Subject: FW: LU/107/20/PL - 15 Beach Road, Littlehampton

I have received the following queries from the HMO officer in relation to the above application. Can you provide clarification please?

SCALE / 1:100 @ A3
DATE / 22.03.2017
DWG. NO / 080616 / TP.02 'A'

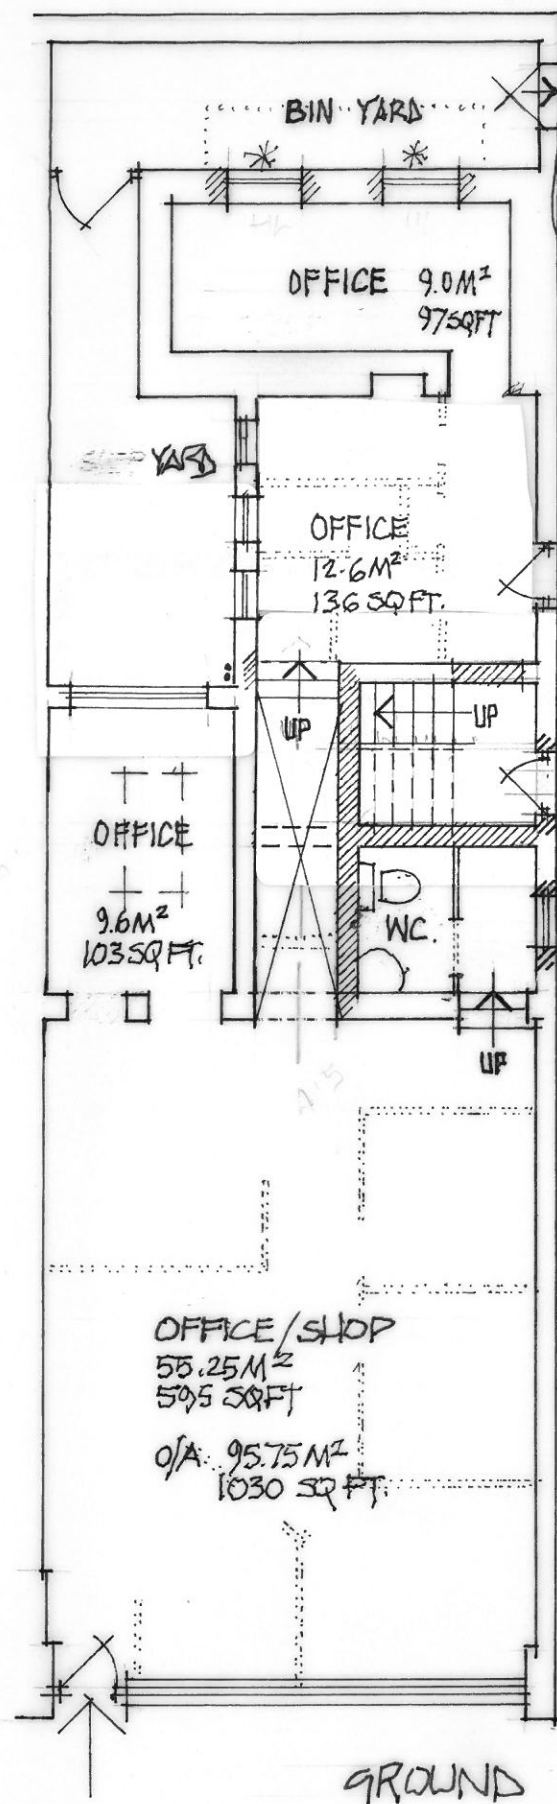
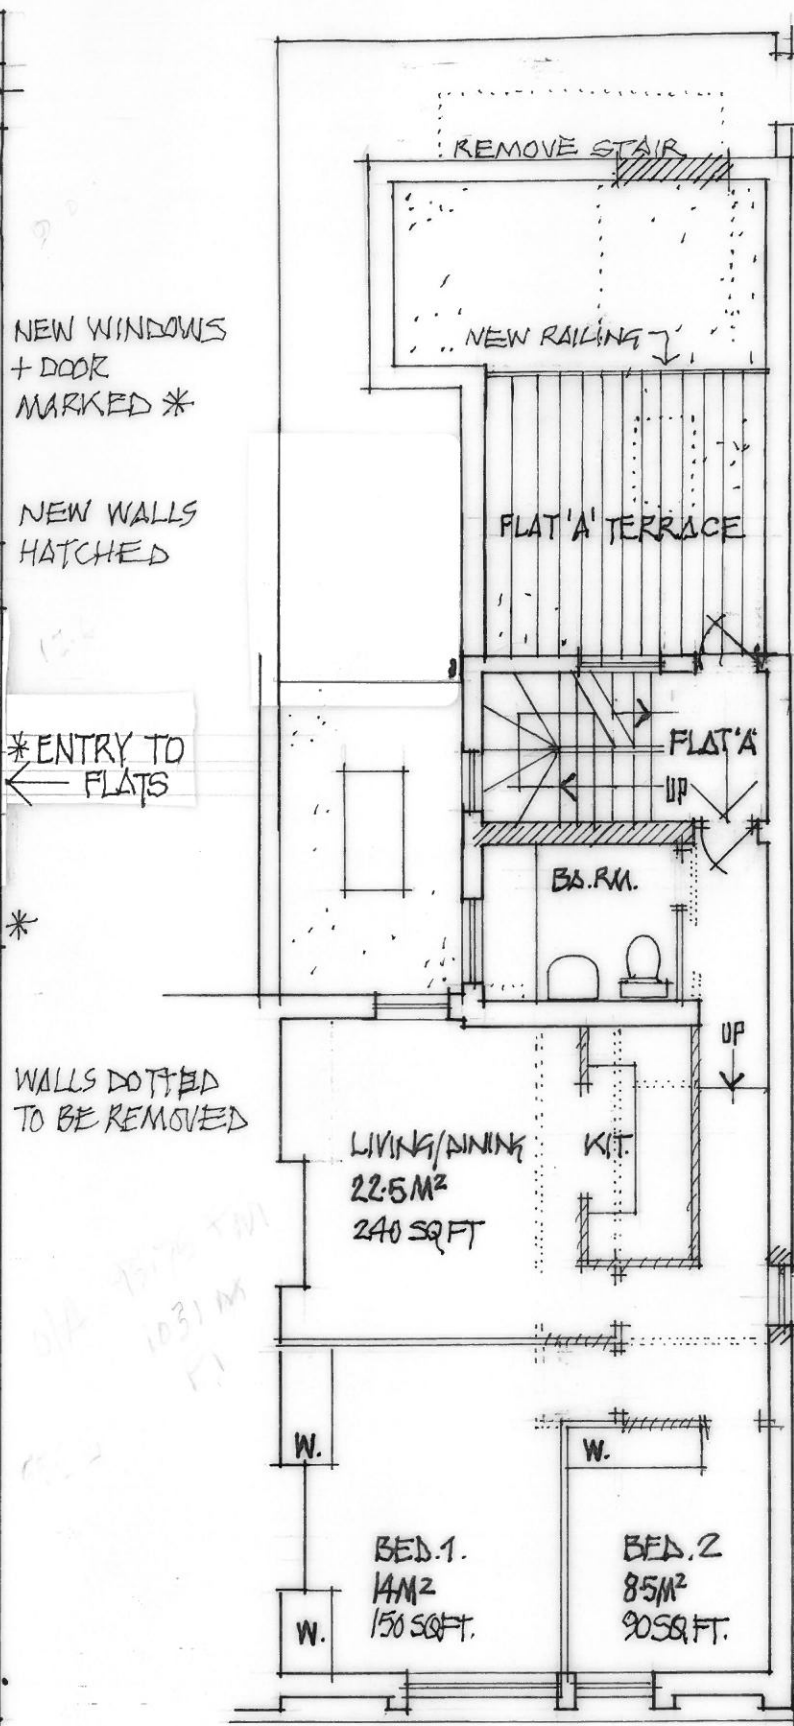
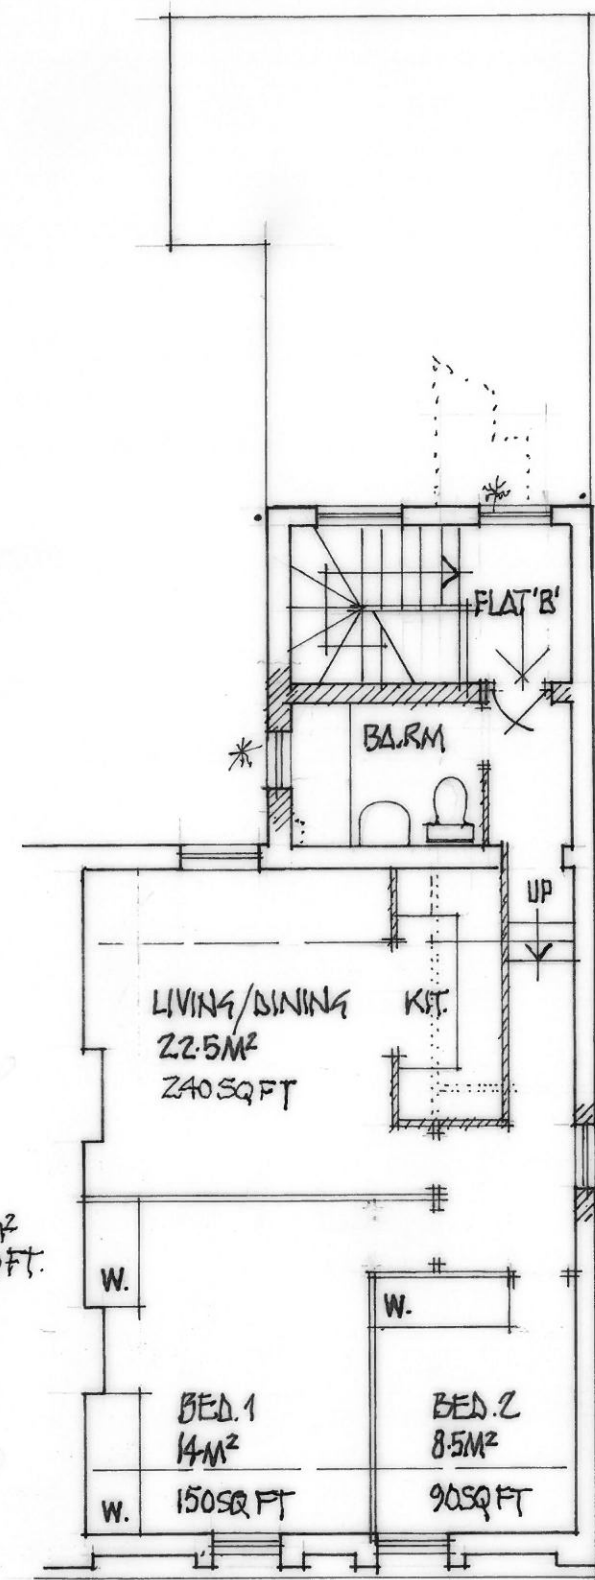
- 1) There are areas on the first and second floors where the letter "W" is written. What does this mean? Wall?
- 2) The applicant has proposed to site the entrance door to the internal communal staircase, located at ground floor level in the entrance road to Manor Car Park. The road itself is rather narrow and to have a residential doorway opening onto it would seem unsafe without a paved/guarded area to exit/enter onto to. My thoughts are that perhaps keeping the external stairs would be a safer option, but I appreciate Flat A wouldn't then have exclusive access to the roof terrace.

- 3) There is no mention of a fire alarm system and what fire-resisting separation there is between the commercial and domestic areas.
- 4) Internal doors are not annotated on the plans supplied for the flats.

- 5) Railings to the Flat A roof terrace have been proposed, but no detail of height and type have been provided.

1. The letter 'W' on the plans indicates a wardrobe.
2. I attach a revised version of the Planning Statement with a new item 12 stating that of course all Building Regulations will be complied with and consent obtained. Details will form part of the future Building Regulations application.
3. The existing side access to the offices and the rear yard gate both open onto the vehicle access at the side of the property. The door is slightly relocated but the same situation is retained. Currently office staff numbers are approximately the same as will be the case when the new residential use is established. The door and gate both open inwards which is normal and does mean that egress is slowed down due to the action of opening them before stepping out. We could apply for

permission the place a bollard each side of the door but this may require Arun D C consent. [See attached sketch]
